Marine
Management
Organisation

Your reference:
BC080001
Our reference:
DCO/2014/000026

Planning Act 2008: The London Resort Limited, Proposed London Resort Theme Park

Relevant Representation

Figure 37. Salt Marsh Extension - Illustrative Concept

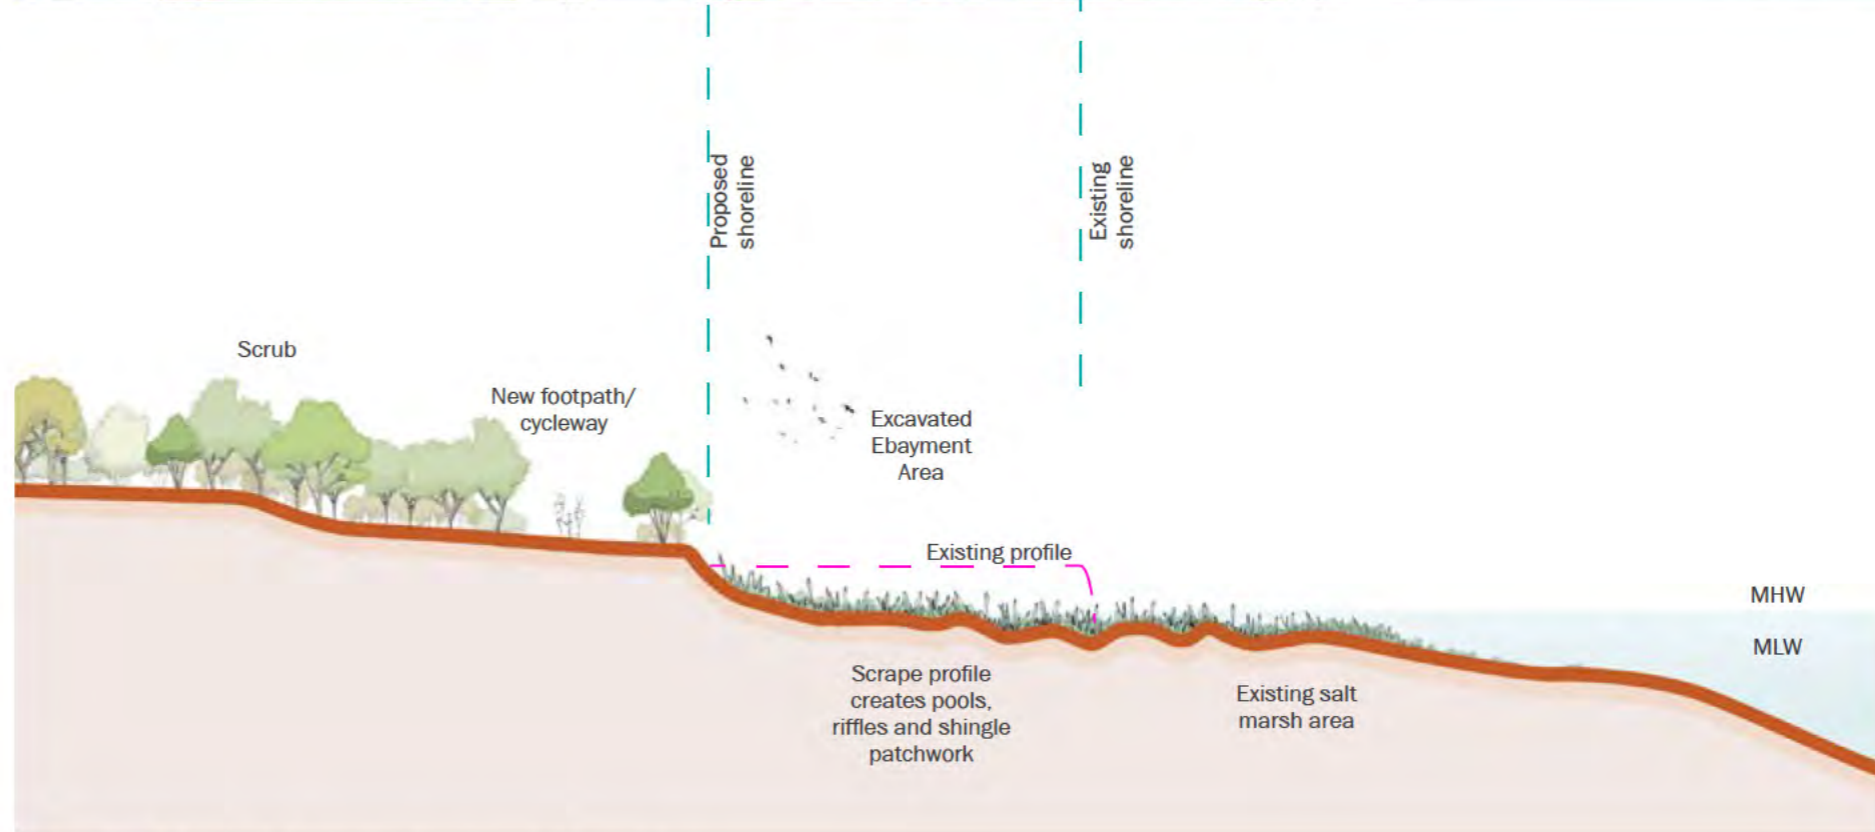
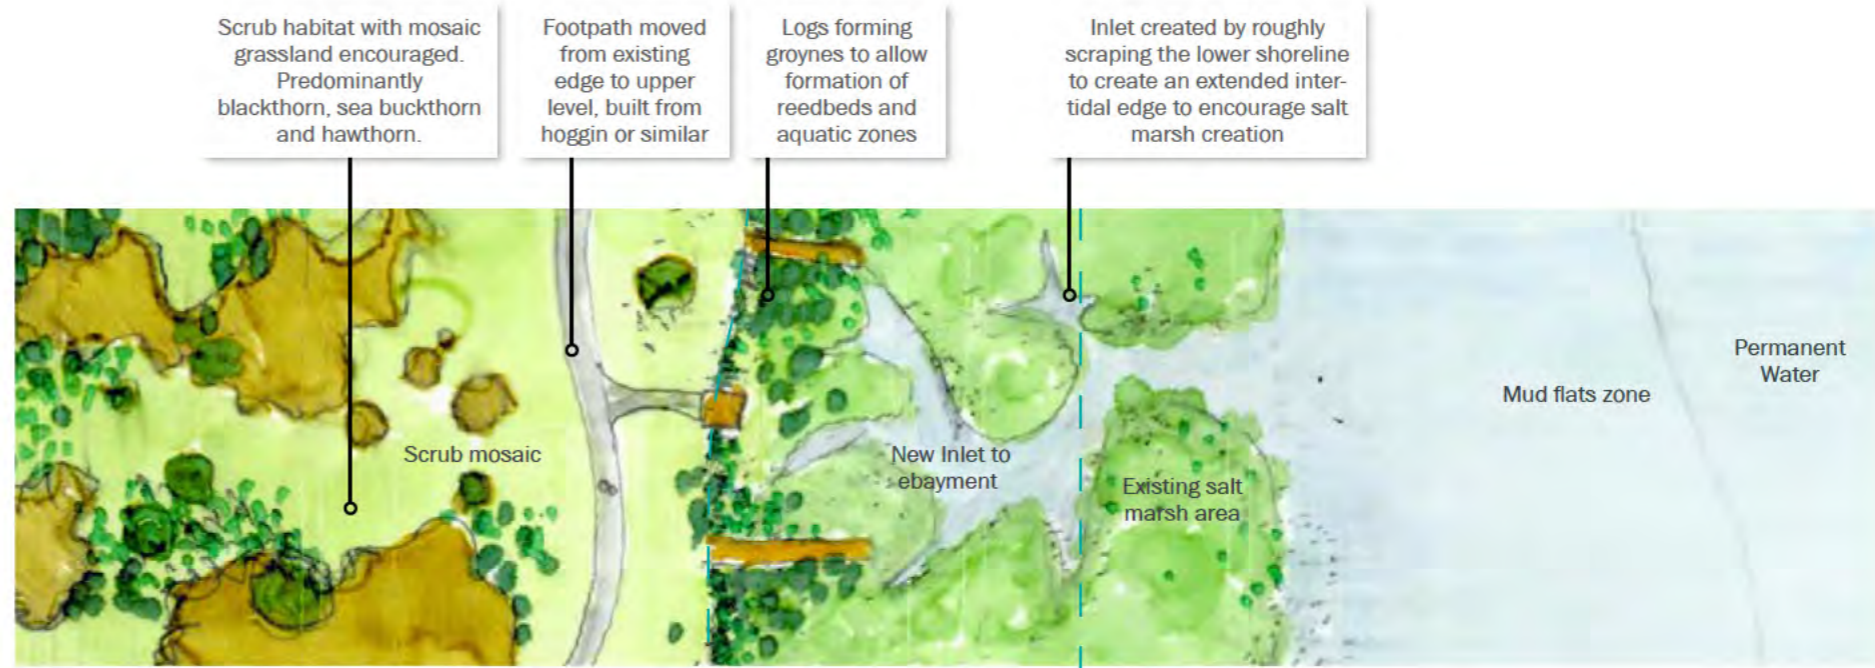
- 3.1.16. In the light of the indication in the Hydrodynamics and Sedimentation Assessment Appendix 17.4 that saltmarsh habitat may potentially establish very slowly, the DML should contain provision to ensure that this benefit is realised as proposed, via monitoring to verify that satisfactory performance is being achieved. The MMO suggest that a condition is added to the DML which stipulates monitoring of saltmarsh habitat over the course of the project. The MMO defer to Natural England for appropriate methods to monitor the habitat.

- 4.1.1. Chapter 3 Project description - Marsh landscape (3.77) The extent of the salt marsh habitat creation as noted in Chapter 3 Project Description, Marsh Landscape must be clarified.
